CITY OF ALBUQUERQUE

Re: Warehouse at 2929 Vassar NE, Engineer's Stamp dated 1-18-07, (H16/D139)

Re: Warehouse Building, 2929 Vassar Dr. NE, Traffic Circulation Layout
Architect's Stamp dated 1-24-07 (H16-D139)

GRADING & DRAINAGE PLAN

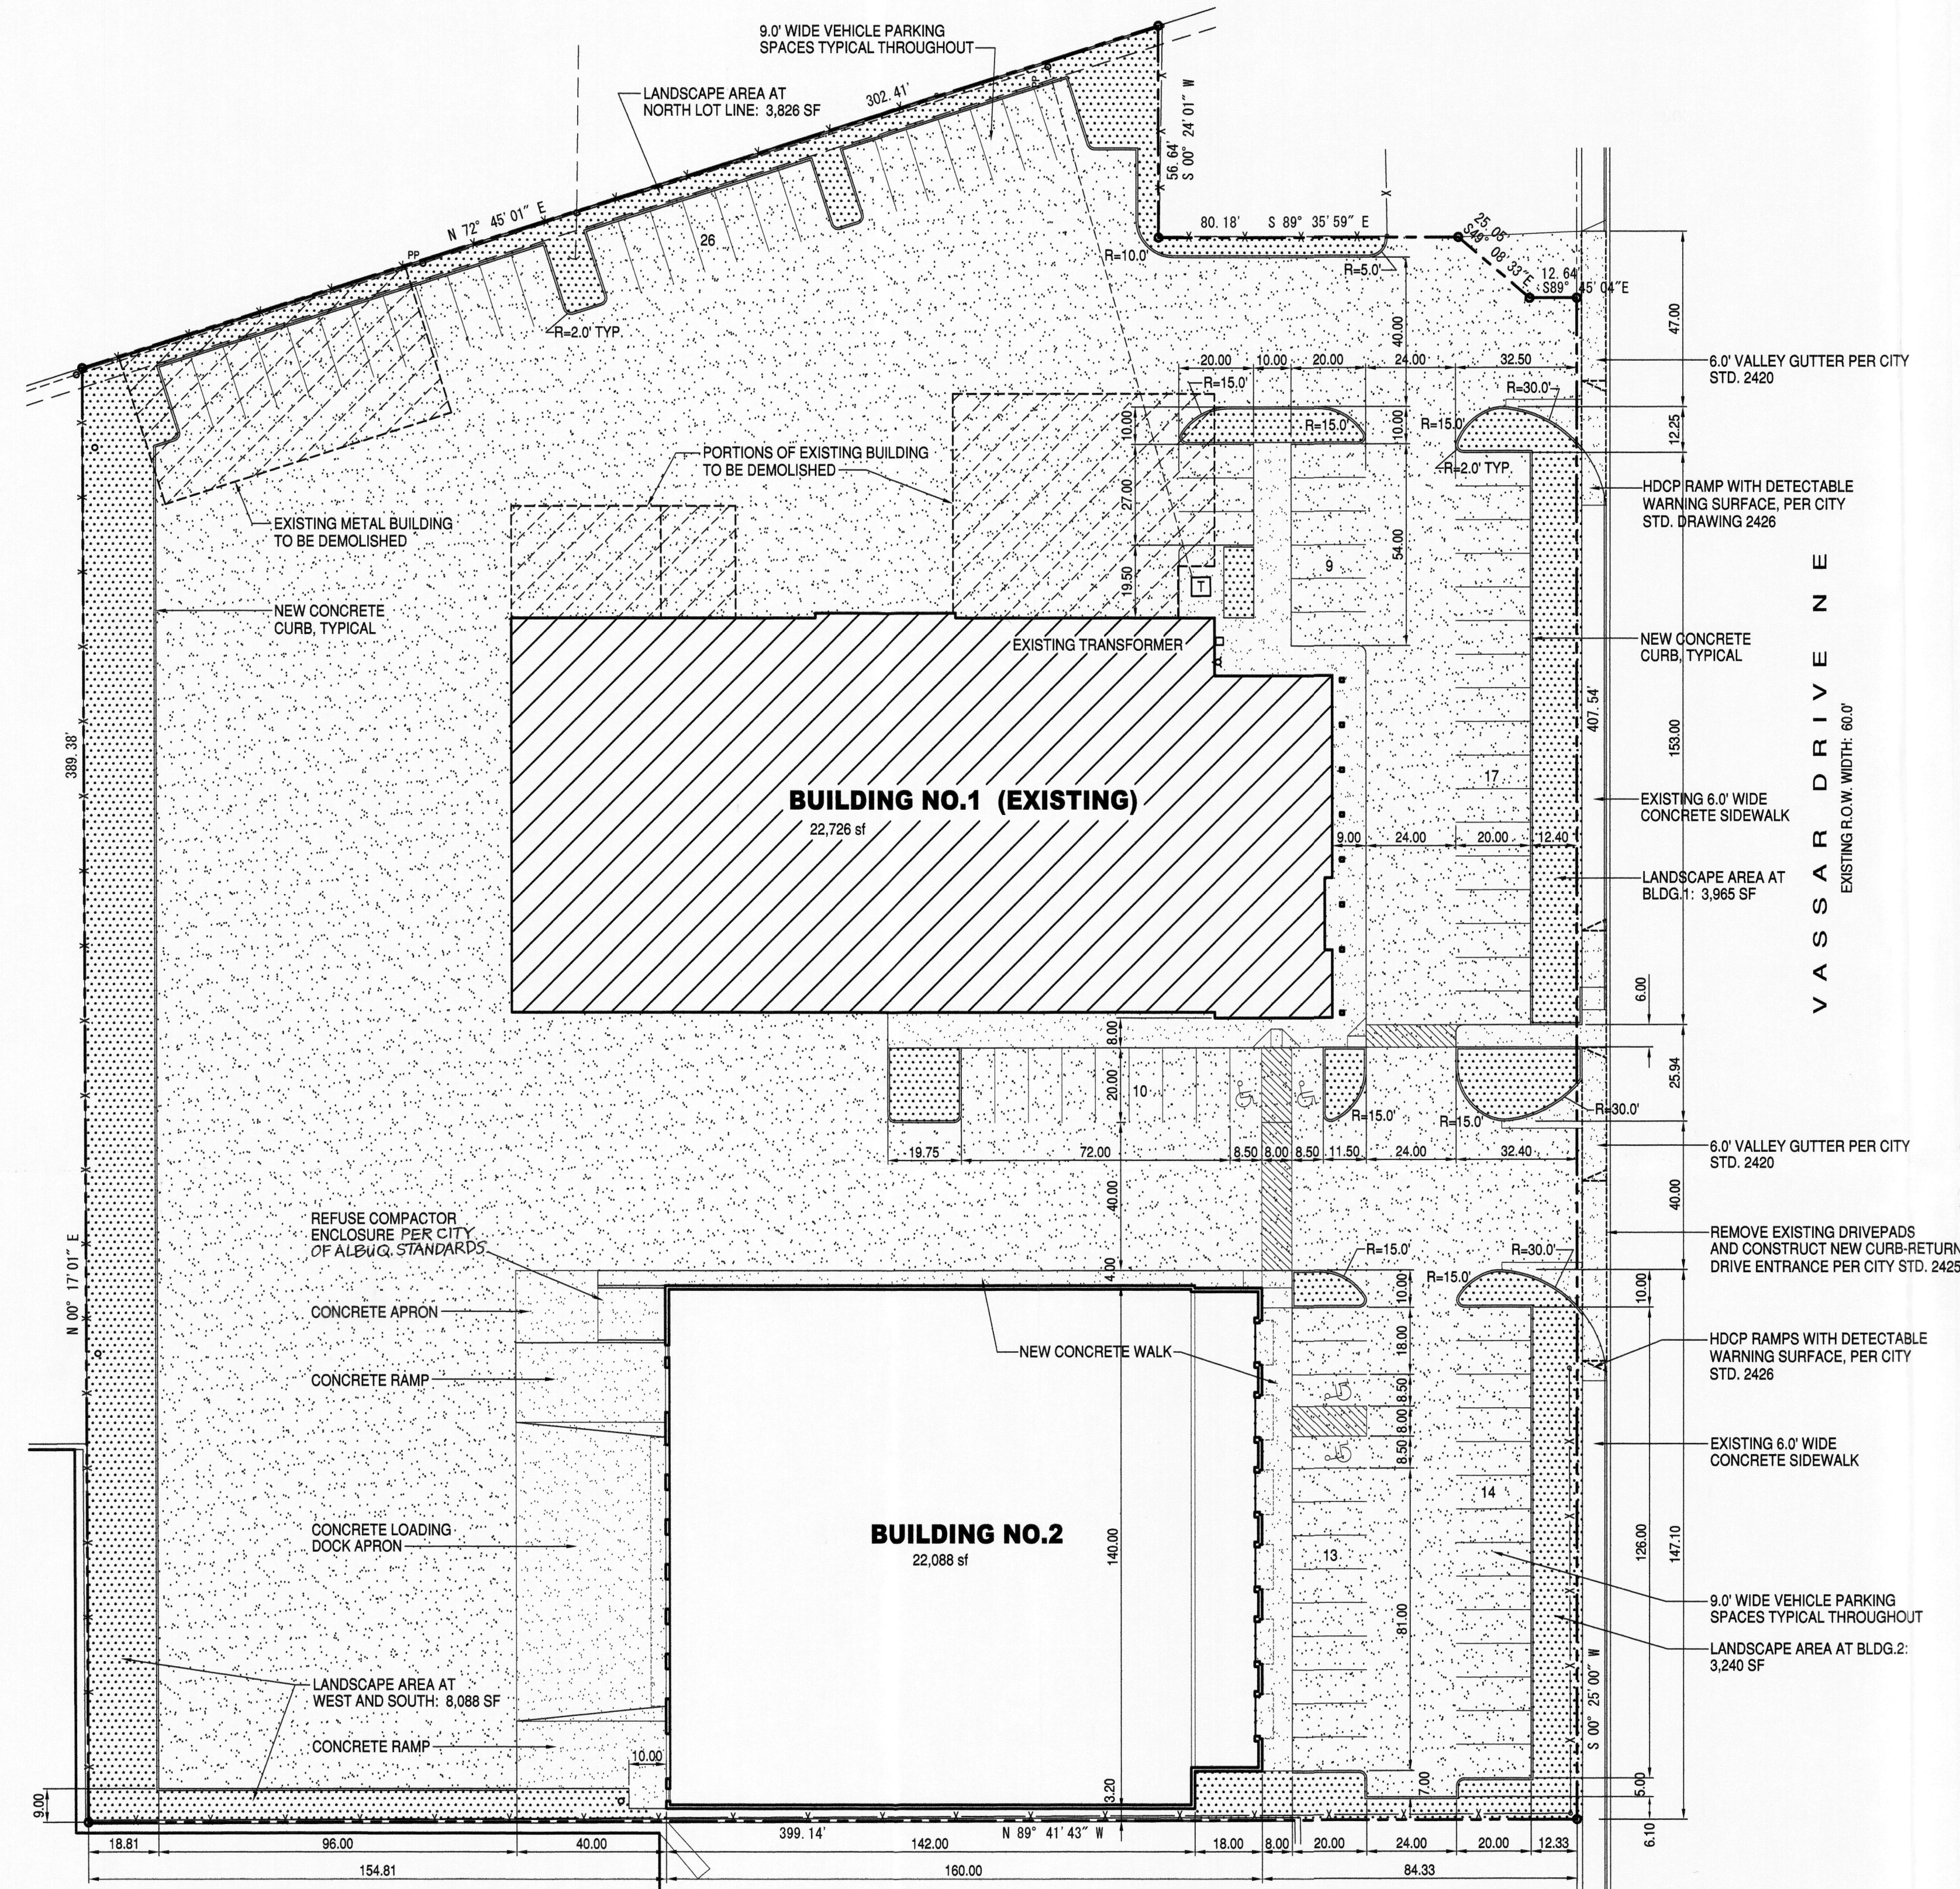
- Your Building Permit submittal does not agree with your TCL submittal. The header curb has been shifted to the west property line thus eliminating the landscape buffer.

- Do the curb spot elevations refer to top of curb or flow line?
- Please call out the applicable standard drawings for the header curb, valley gutter, wheel chair ramps, and sidewalk culverts should they be utilized. Also provide the quarter-point spot elevations for the new curb returns.

- Provide a detail and inverts for the proposed concrete rundowns to the alley. Are these rundowns to be constructed under Building Permit or work order?

- Your water block at the southern driveway is shown as being perpendicular to the proposed contours. Is the intent to make the southeast parking area a separate basin? Please clarify.

- Does the southern retaining wall currently exist in its final configuration or will it be constructed / re-constructed with the site work? Construction will require the inclusion in the plan set of a cross section detail along with top of wall / bottom of wall elevations.

- How will the area in between the retaining wall and new structure drain? Will it be concrete, asphalt, or landscape?
- Is the southeastern landscape area intended to also function as a retention pond? If not, please provide a mechanism to drain this area without overtopping the handicap ramp.

- With the reconfiguration of the northern driveway, you will need to relocate the existing water meter outside of the proposed valley gutter.
- Please provide a note stating that a drain line is required between the refuse enclosure and the sanitary sewer system.
